359 Kent Street, 436 and 444 MacLaren Street, Ottawa

Planning Rationale Addendum No. 2
Official Plan and Zoning By-law Amendment
July 28, 2023

DRAWING TITLE:
ELEVATIONS

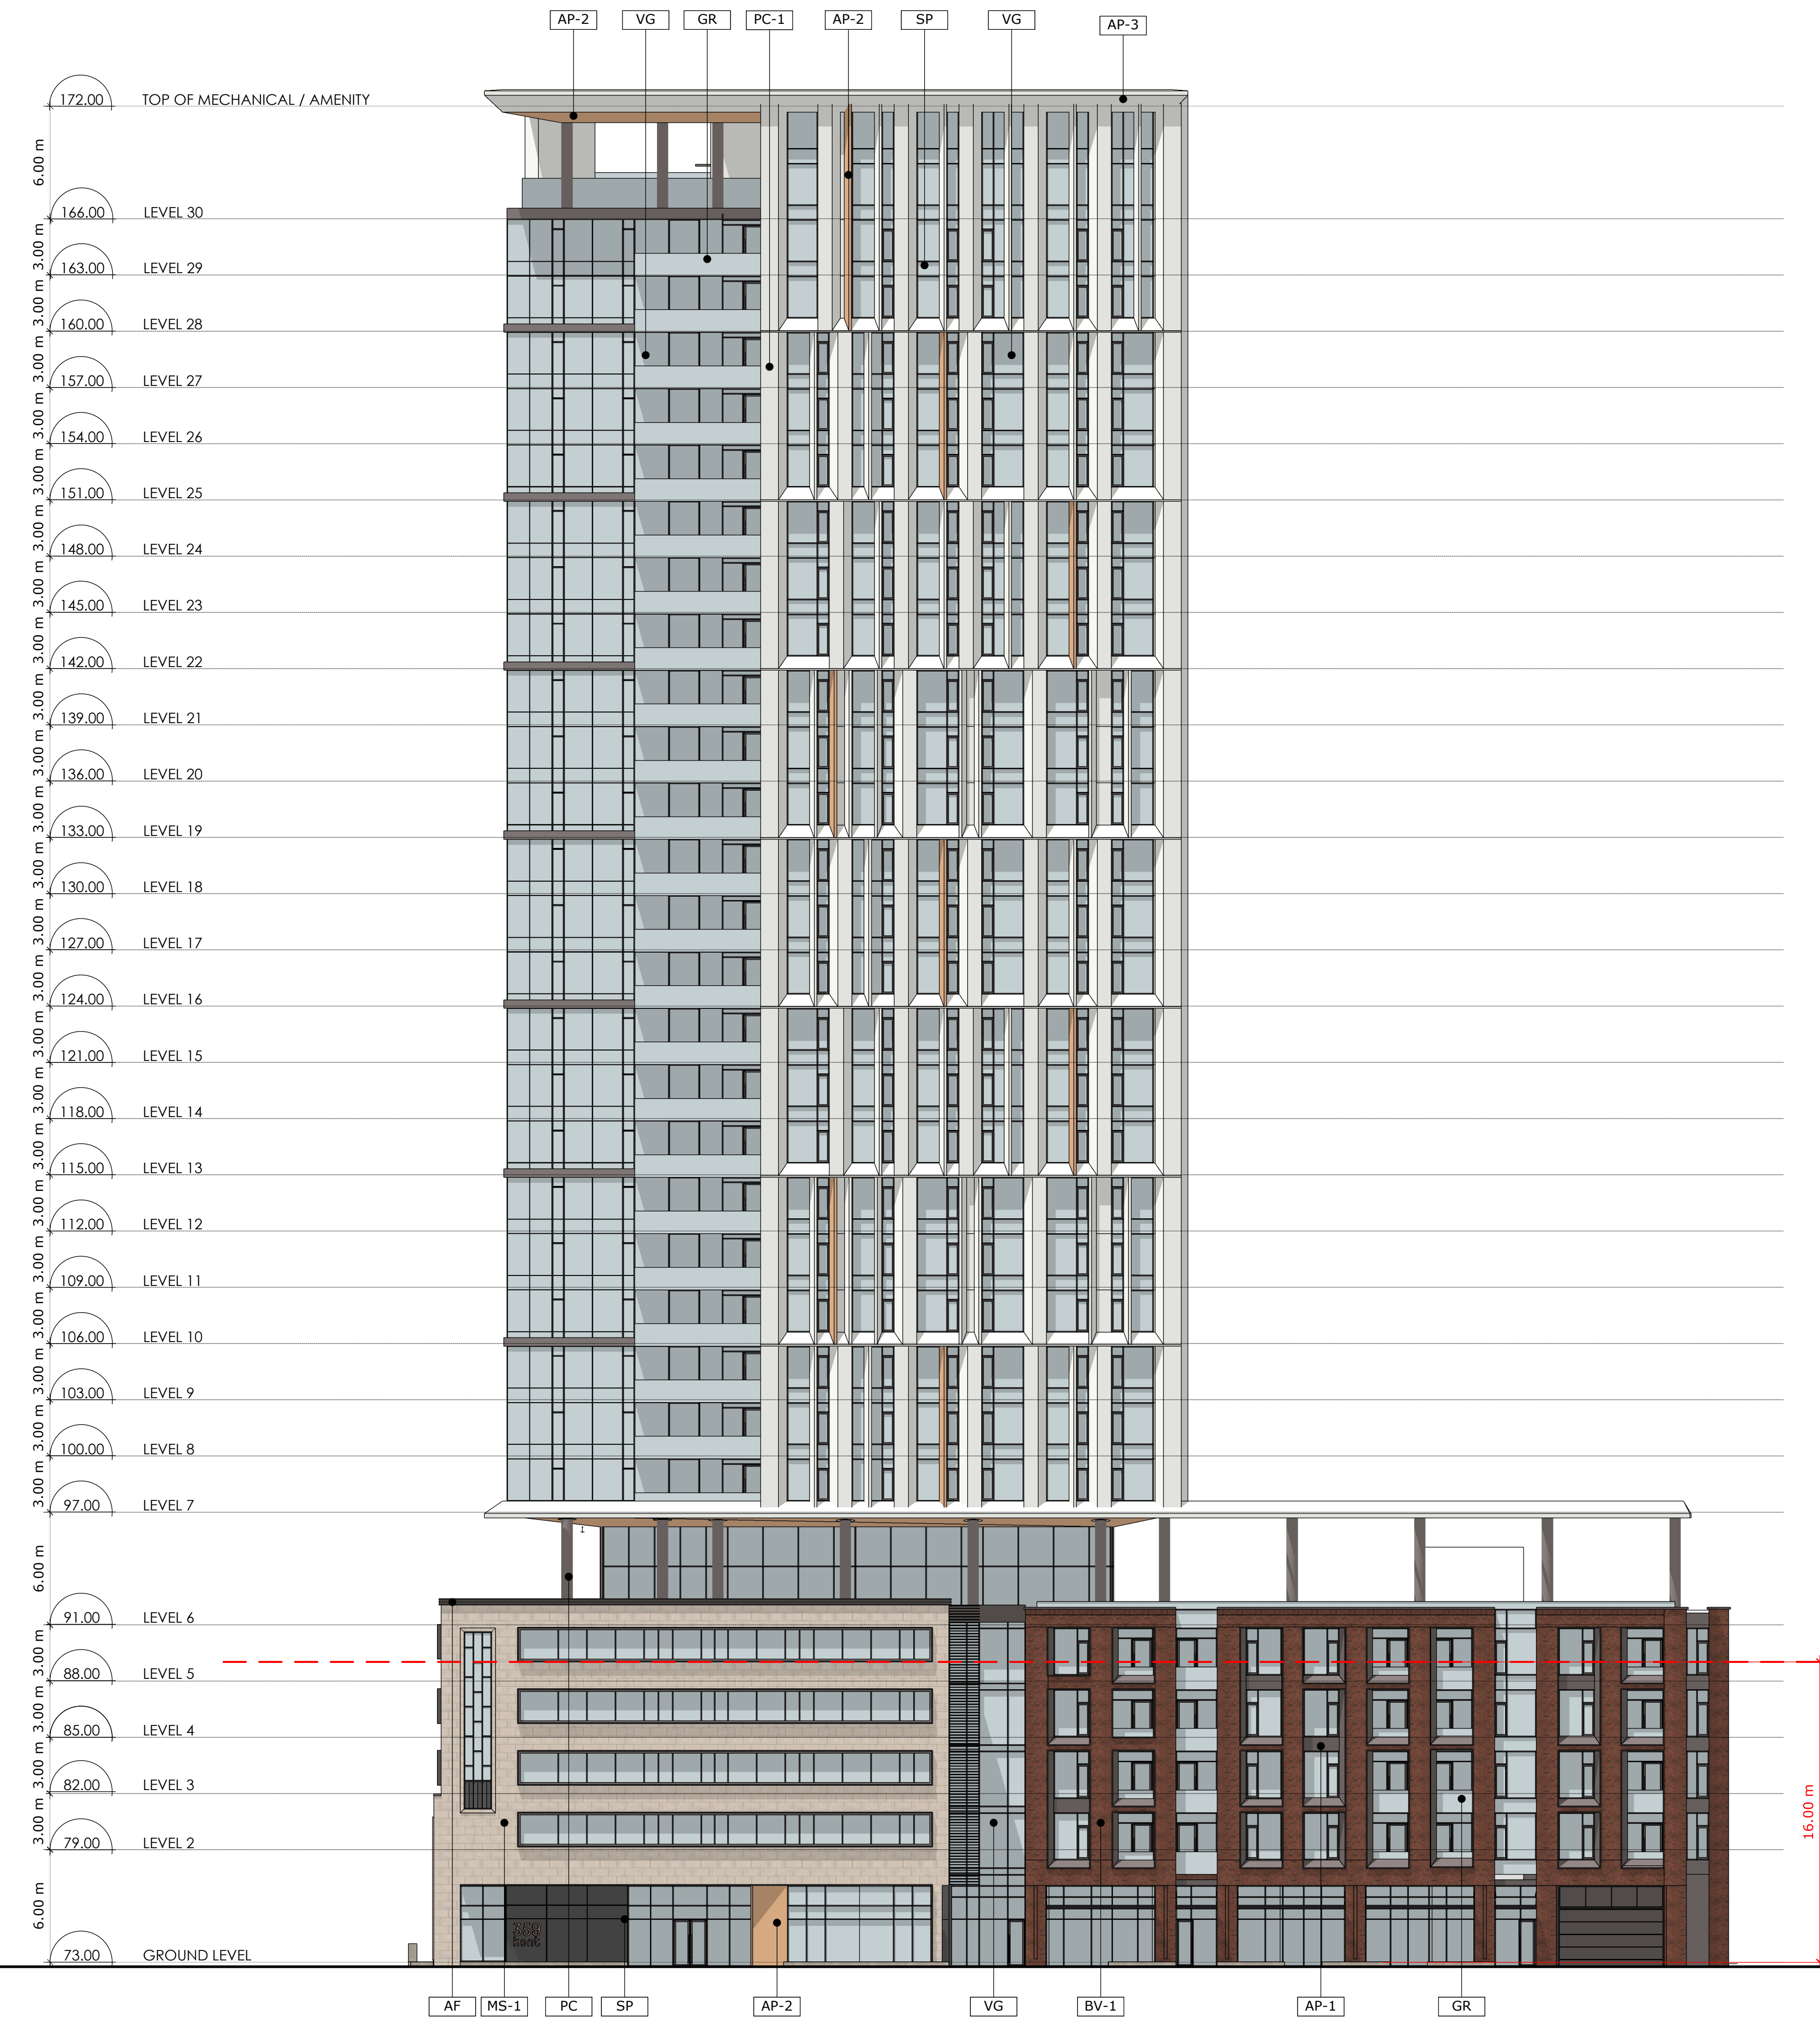
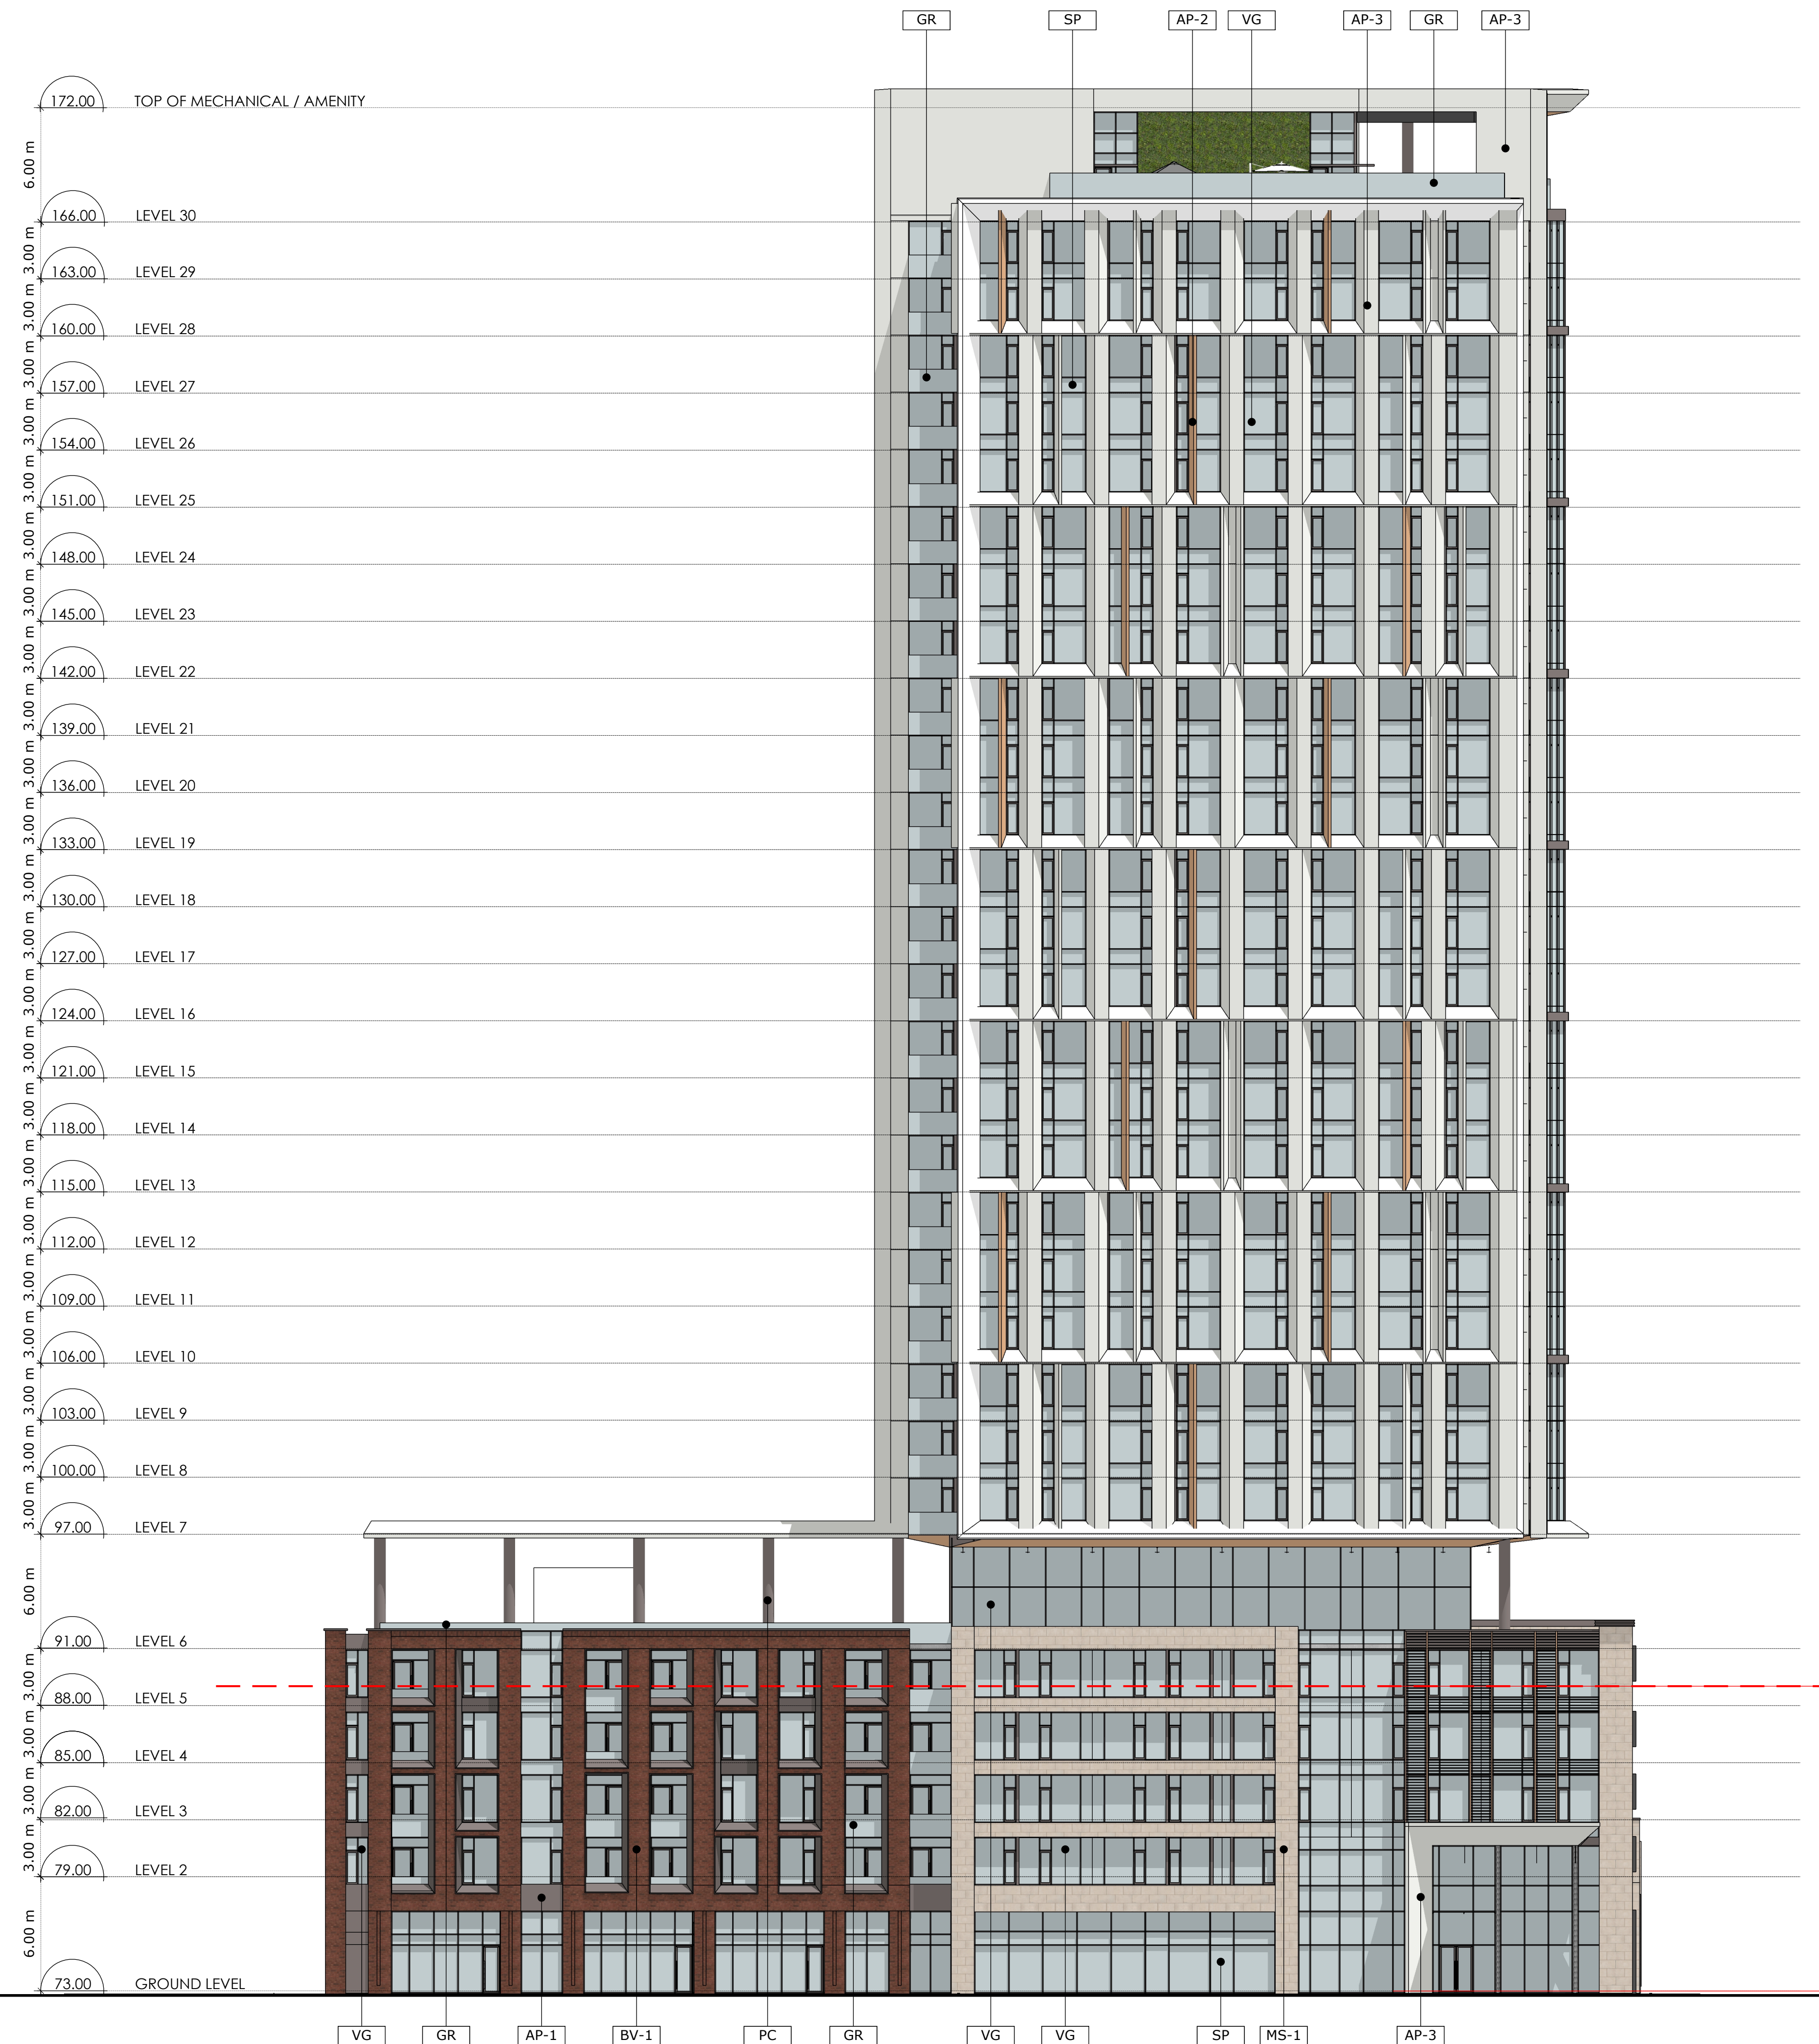
- 14 Staff recognize and appreciate that the podium height has been reduced to five storeys, which provides better transition in height to the existing low-rise context to the east than the previous development proposal.
- 14a However, the revised proposal negatively impacts the existing buildings at 422 and 430 MacLaren Street with respect to the proposed setback of 4 metres on the north property line, whereas the previous development proposal was for a setback of 8.5 metres. Further to this, there is no discussion of the impact of this minimal setback within the Planning Rationale, and the zoning provisions provided within Section 3.5 of the Planning Rationale do not provide an accurate comparison of the required setback compared to the proposed along this property line.

- 14b Furthermore, the five-storey podium should introduce elements of transition to provide better transition to the east, such as a stepback on the east side on at the 3rd or 4th storey.

- 14c Staff are of the opinion that the podium rooftop canopy negatively impacts the revised podium height and transition of the proposed development to the planned and existing low-rise context and recommend that this be removed from the development proposal.

The podium of the development has been further reduced from the original 8-storey height, and the previous 5-storey height, to a current height of 4-storeys. This provides a stepped transition from the existing low-rise context through the 4-storey eastern podium to the 5-storey height of the retained 359 Kent Street façade. The canopy atop the eastern podium has also been removed to reduce the perceived massing of the podium.

The rooftop canopy has been removed to facilitate better transition to the planned and existing context.
